Subdivision Comments

From: Holly Erdman, Environmental Health Specialist II

RE: SP-21-00002 Lonny

LONNY SHORT PLAT
PART OF SECTIONS 1 & 2, T. 19 N., R. 15 E., W.M.
KITTITAS COUNTY, WASHINGTON

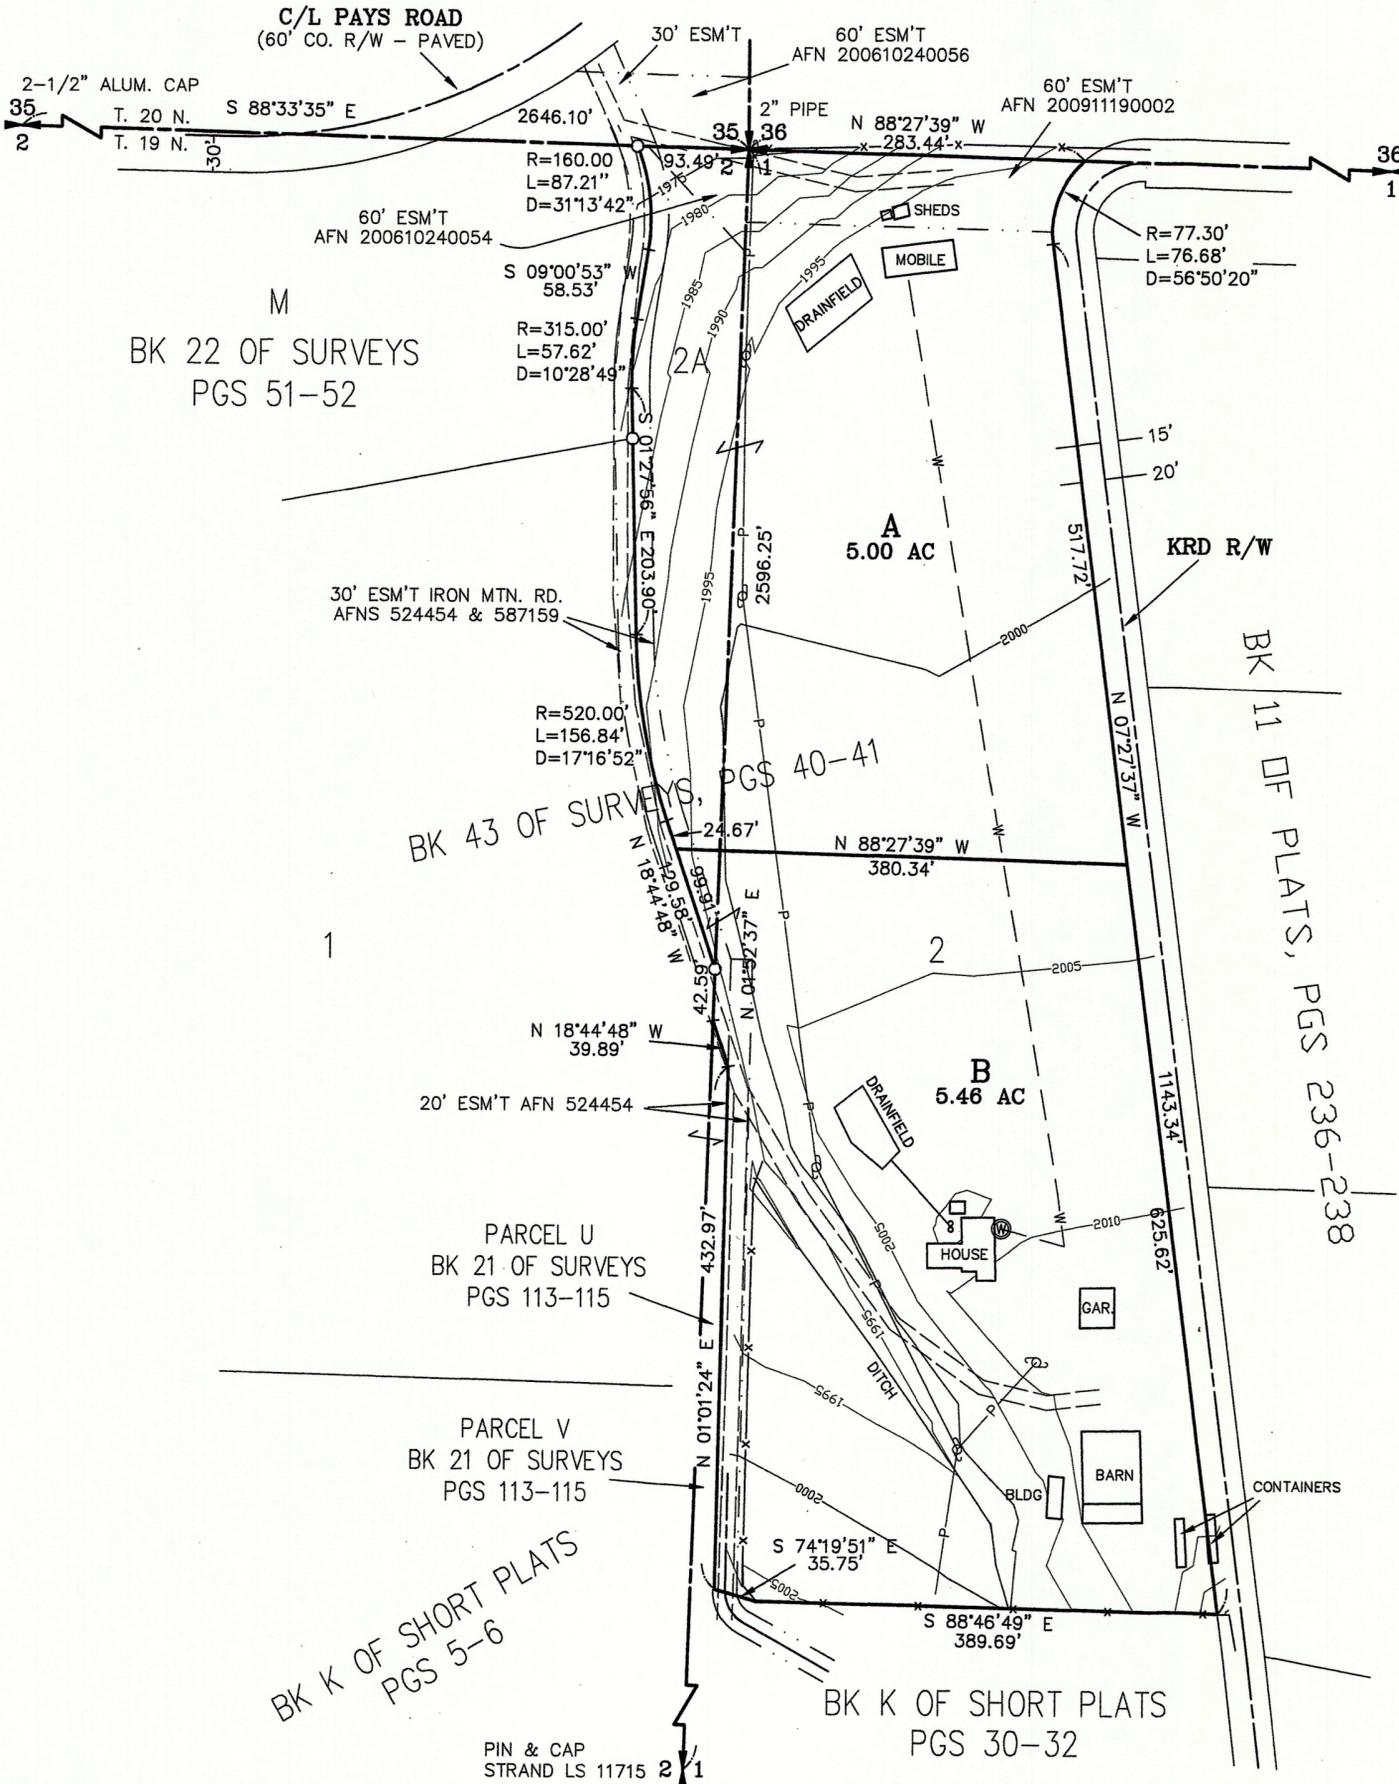
The proposed short plat indicates the applicant will use a shared well to serve both lots.

The applicant must provide a signed, notarized and filed shared water user's agreement between the two proposed lots of the plat.
